Commitment Letter

Project Name: Warner 5-Lot Subdivision

Description: Warner 5-Lot Subdivision is proposed with five (5) residential lots. This approximately 40 acre subdivision with the address of 17350 West Goshawk Road is located north of Hodgen Road in Section 23, Township 11 South, Range 65 West.

Warner Subdivision  
Lots and Easements  
Project No. 2019092  
February 17, 2022  
Sheet 3 of 3

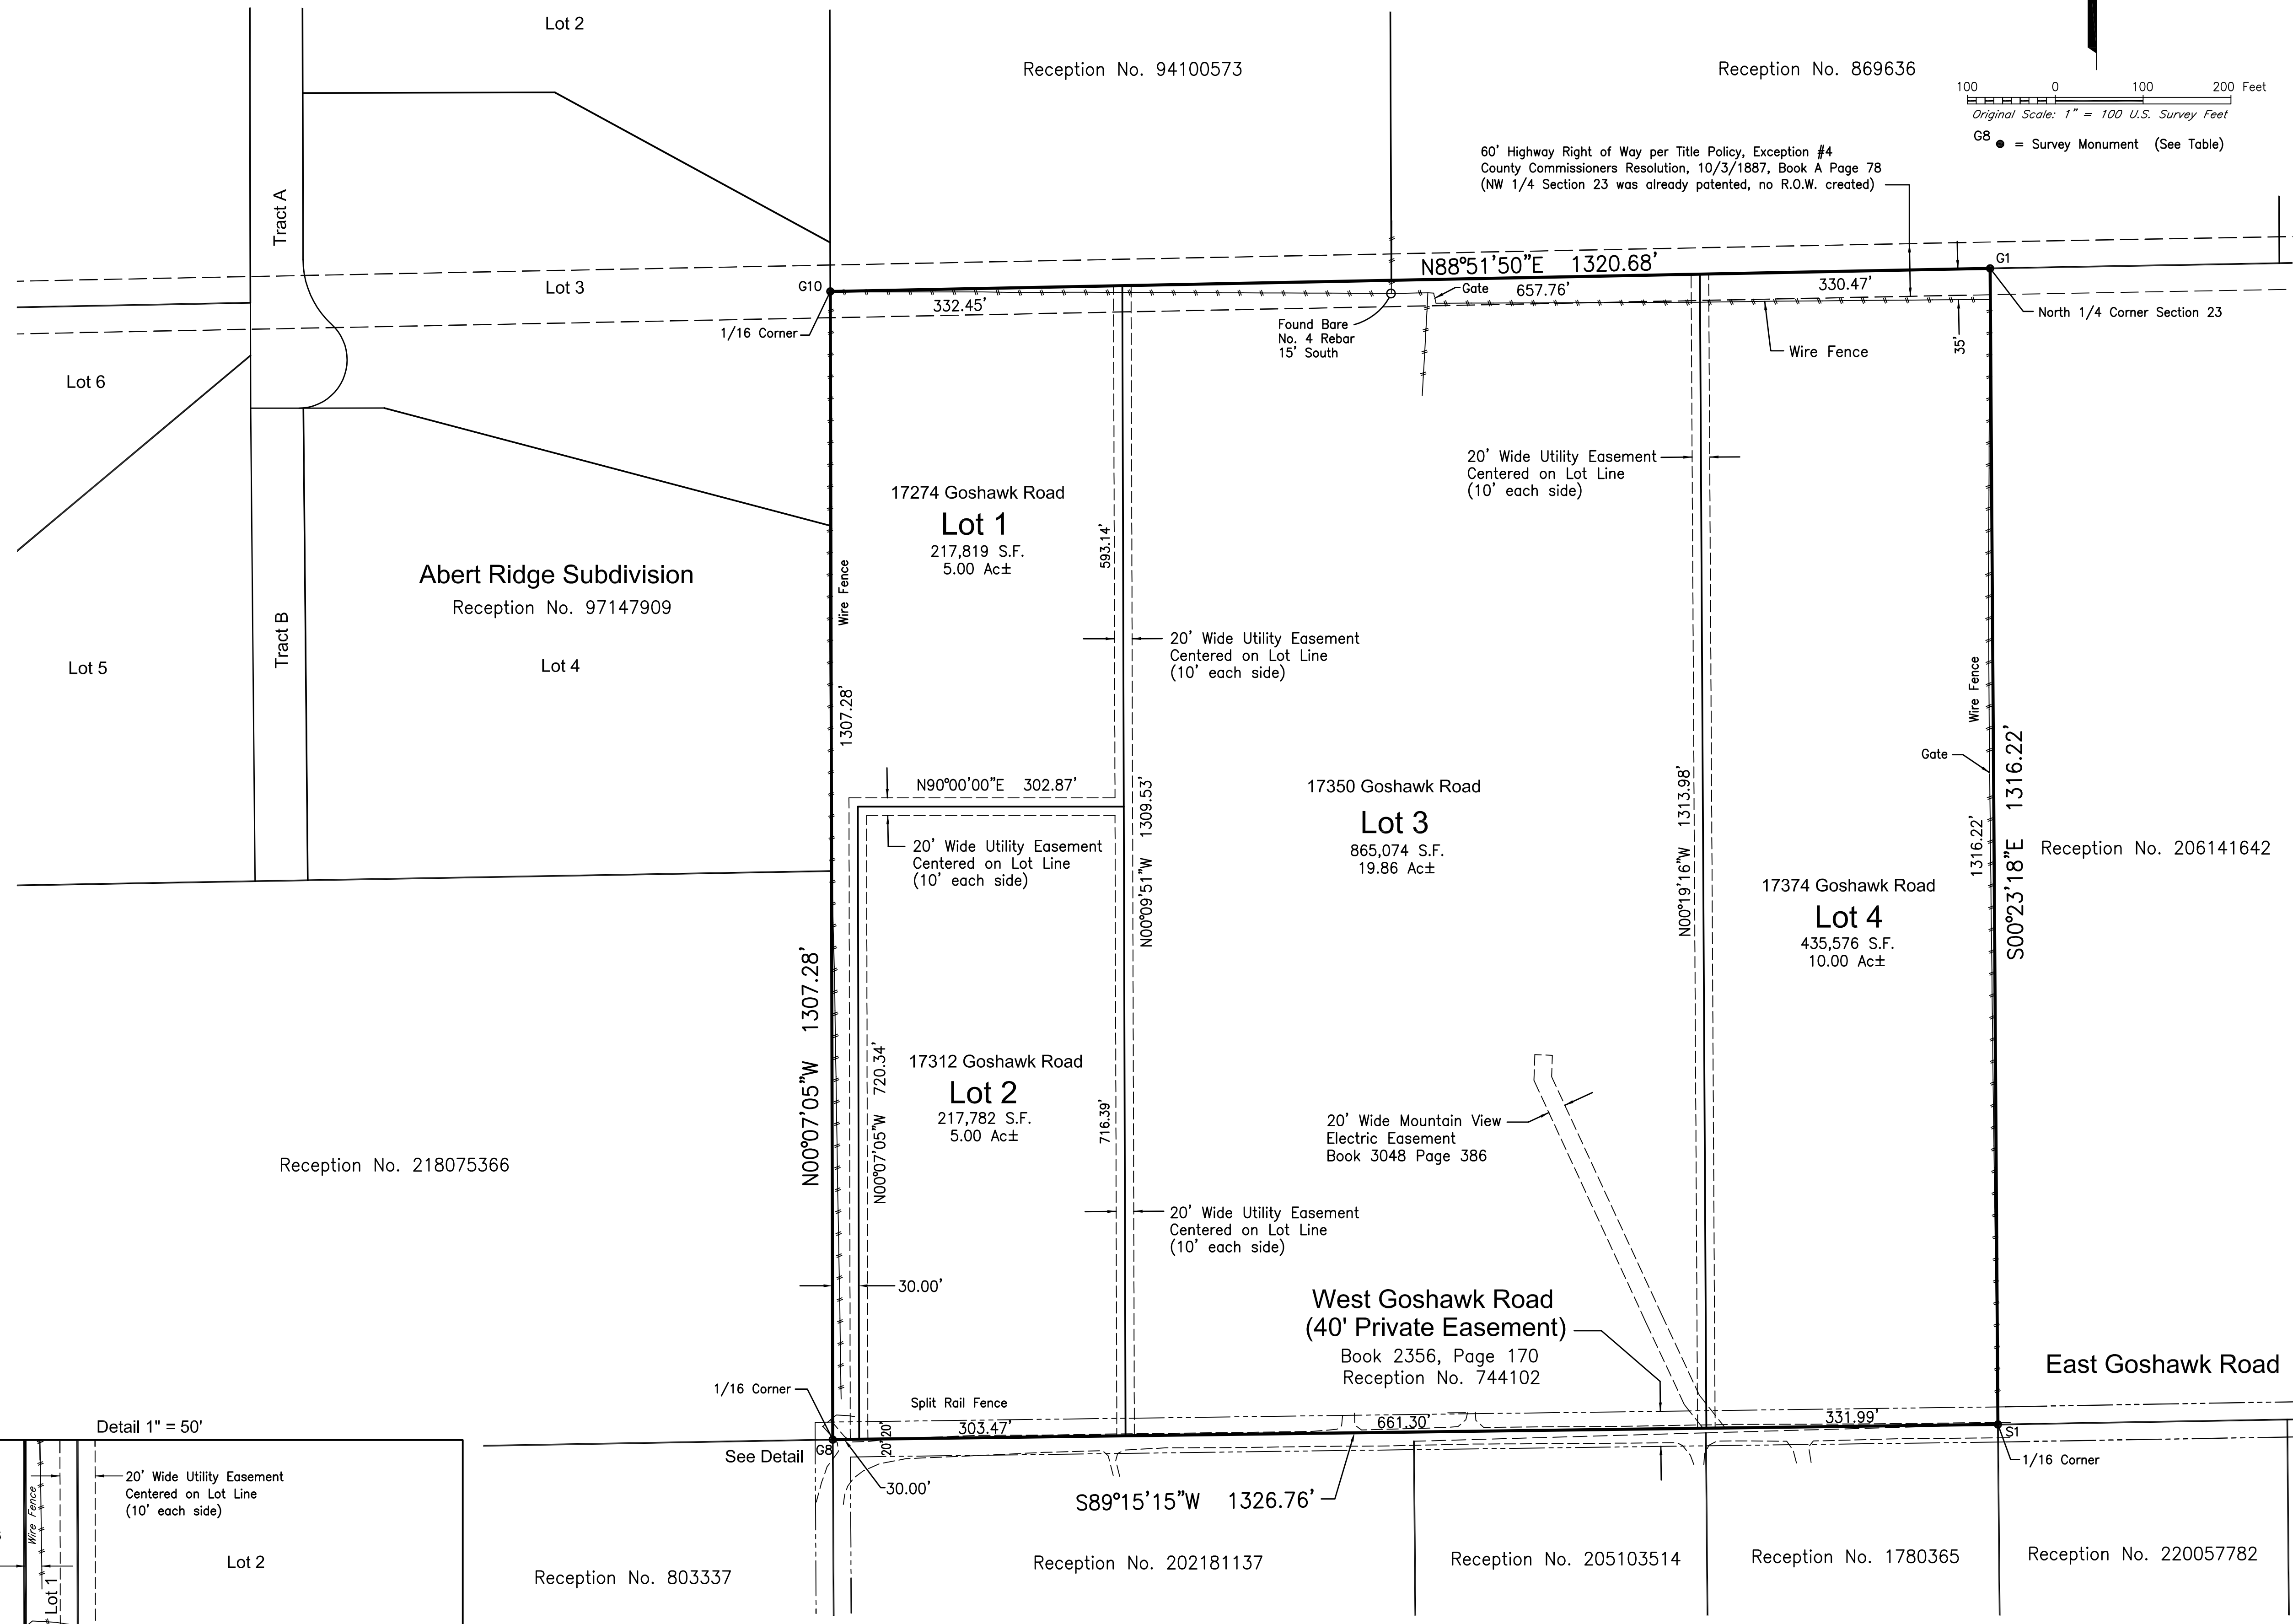
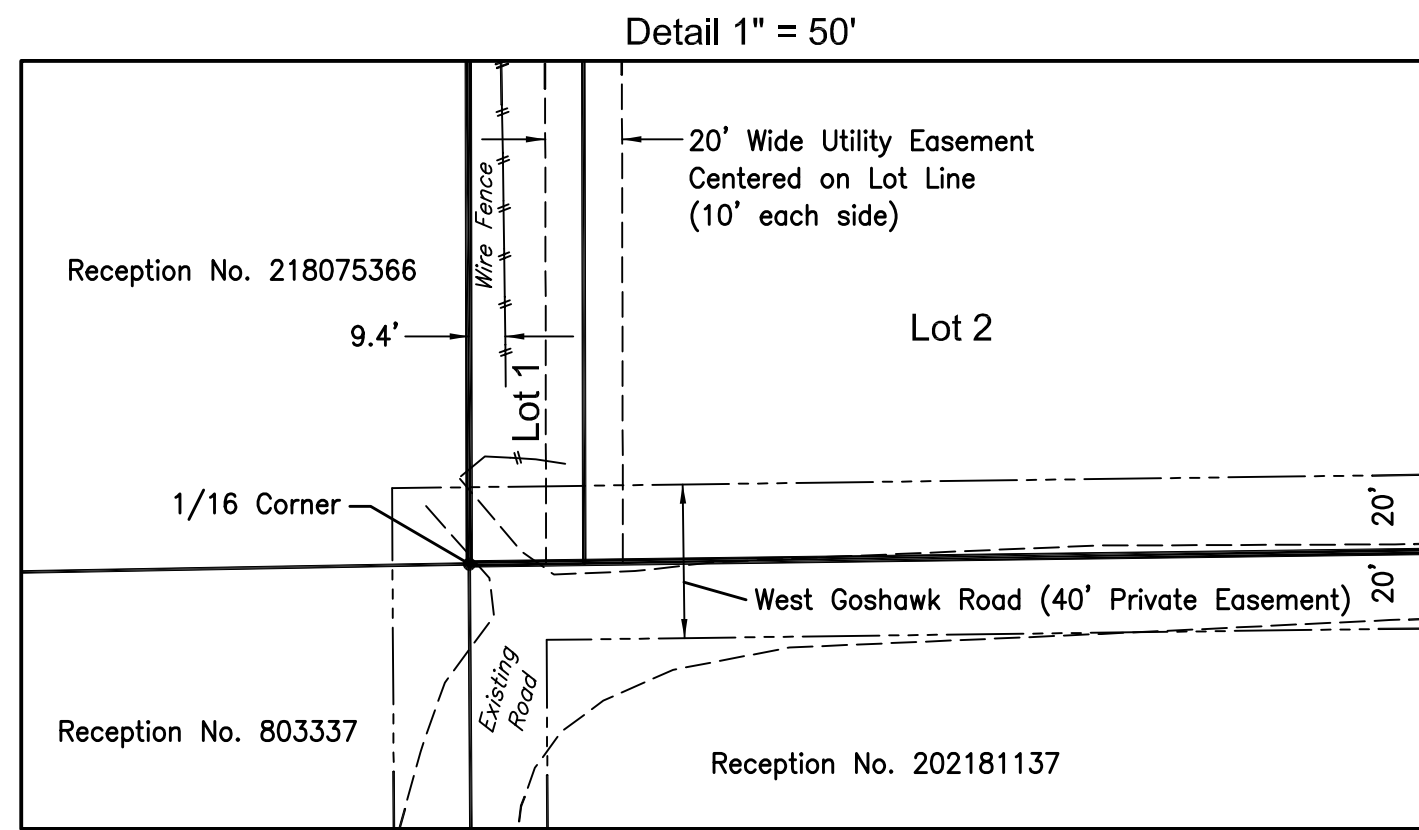
MVEA requests a ten (10) foot utility easement along all common side lot lines and a twenty (20) foot exterior subdivision utility easement. Additional easements may be required once a review of civil drawings with grading and erosion plan is provided to MVEA.
